Lakes Estate Residential Subdivision Modification 3

State Significant Development Modification Assessment
(MP 05_0129 MOD 3)

May 2020

Subtitle: Assessment Report

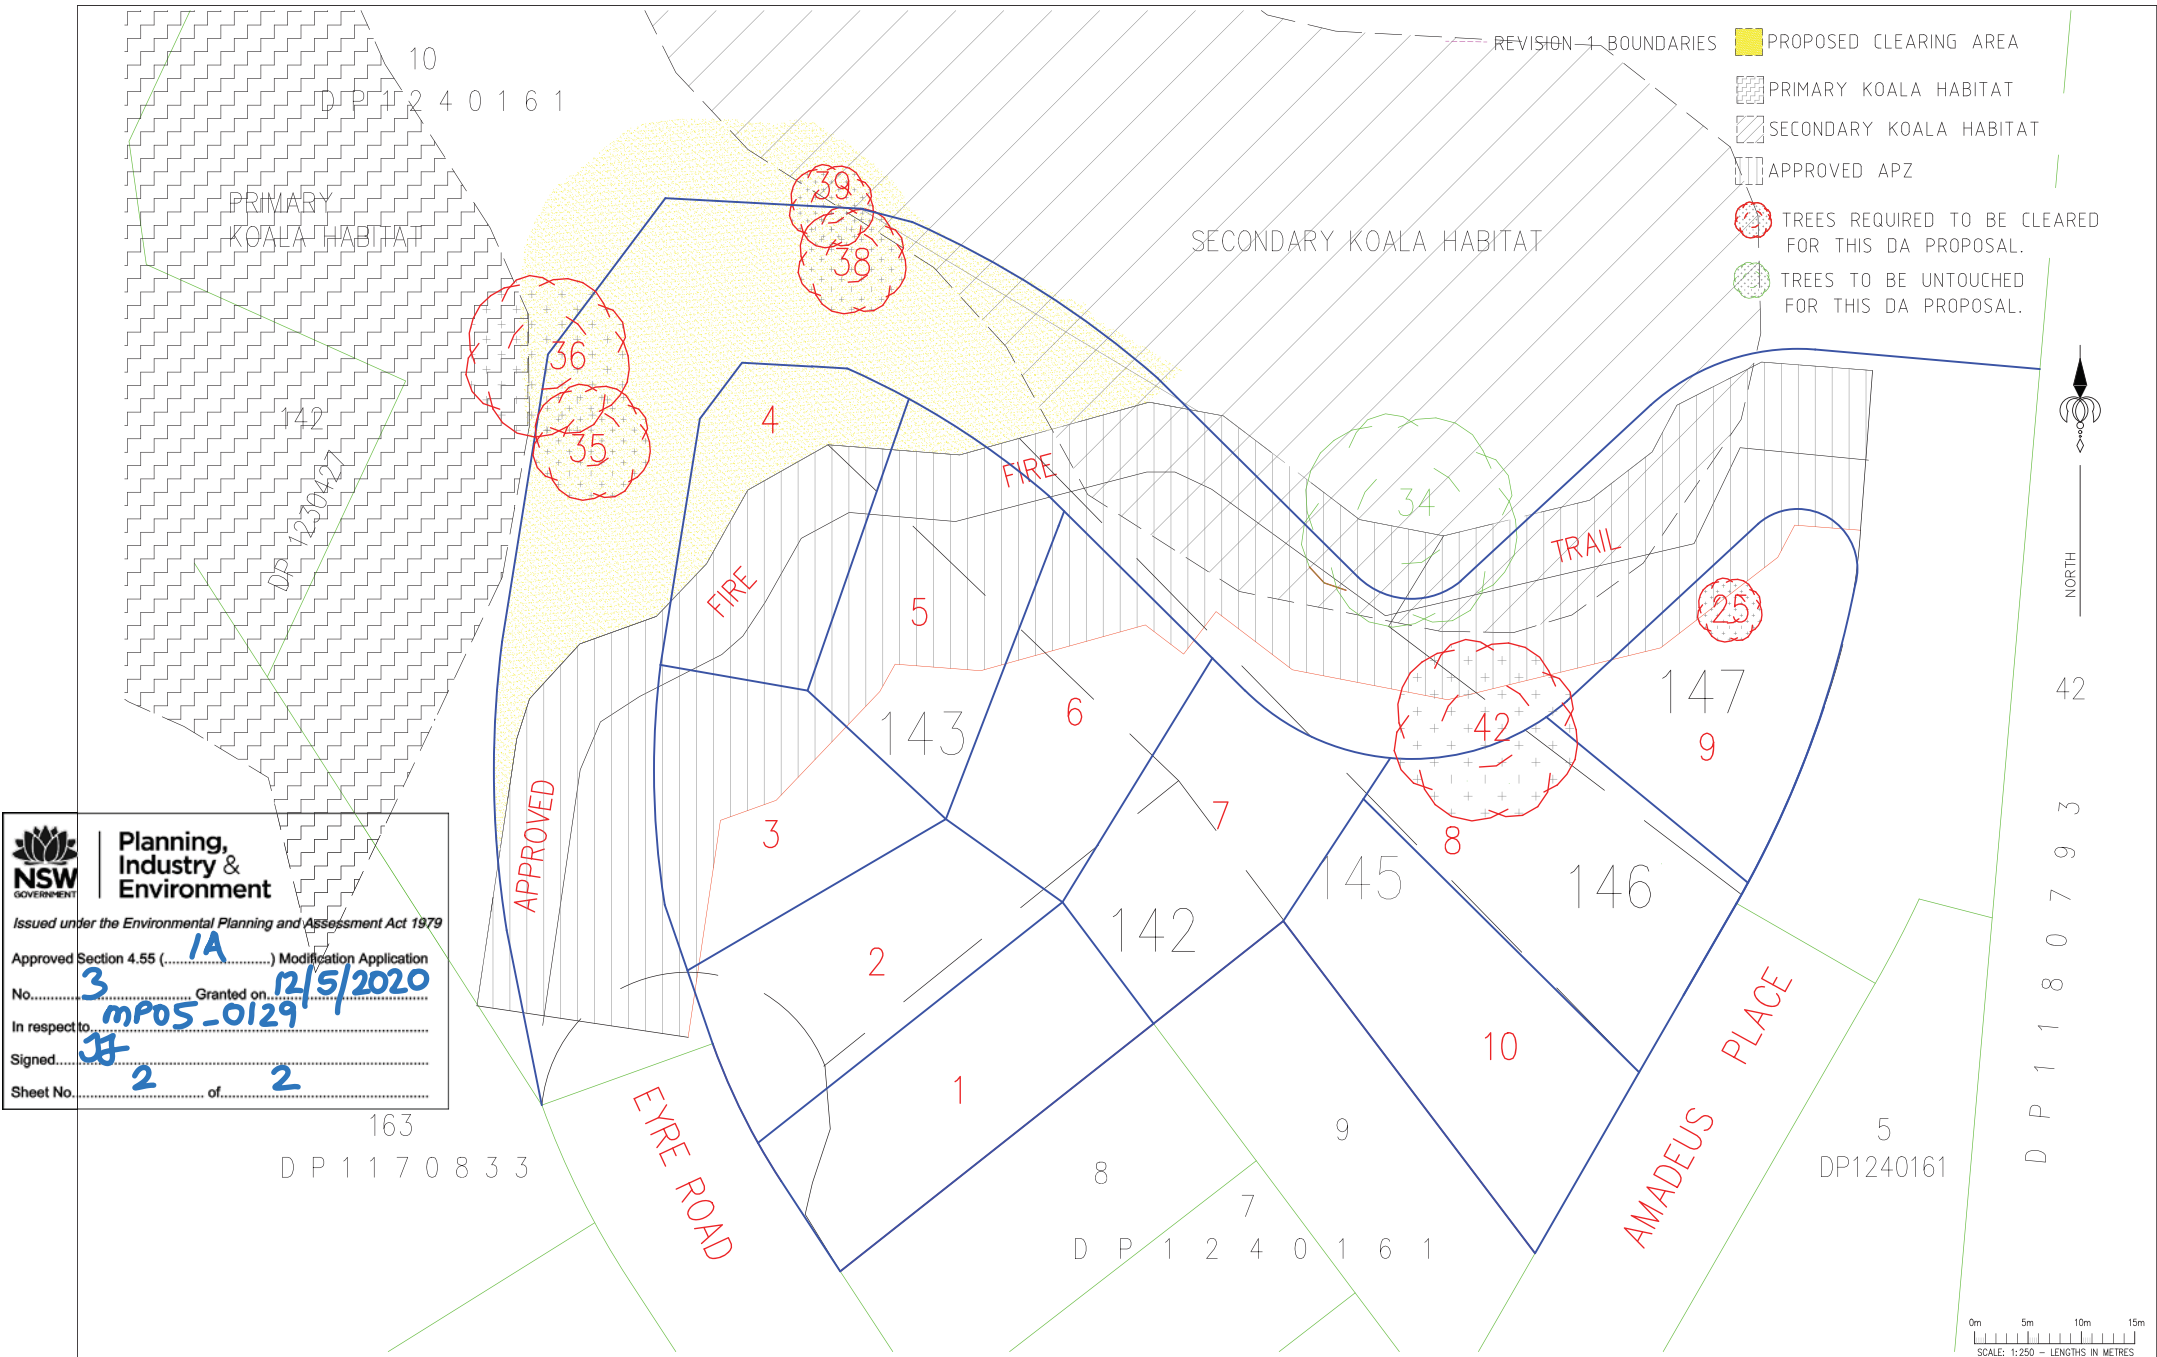
- current road design incorporates a verge of 3m, which does not meet the minimum Auspec requirement of 4m. If a reduced verge width is supported, it must be demonstrated that all services can be accommodated

- proposed grade of the new public road (20%) is not in accordance with Auspec requirements which requires a maximum of 16%
- speed to radius relationship of the new public road does not appear to be in accordance with Council's specifications

- verge slope for the extension of Amadeus Place should be in accordance with Austroads and Council Standards
- extension of Amadeus Place must have a carriageway width of 8m in accordance with Planning for Bushfire Protection.

Council initially raised concerns that the carriageway width did not comply with the required 8m in the PBP 2006. However, in response the Applicant provided amended plans showing an 8m wide carriageway as part of the RTS.

Council reviewed these plans and raised concerns that the detailed road design did not comply with relevant Council and Auspec specifications.

The Department notes these concerns relate to detailed engineering design matters, and has therefore recommended a new Condition A5A requiring amended plans showing the road designed in accordance with Auspec specifications to be approved by Council.

New Condition A5A requiring amended plans to be approved by Council showing the road design amended to comply with Auspec specifications.
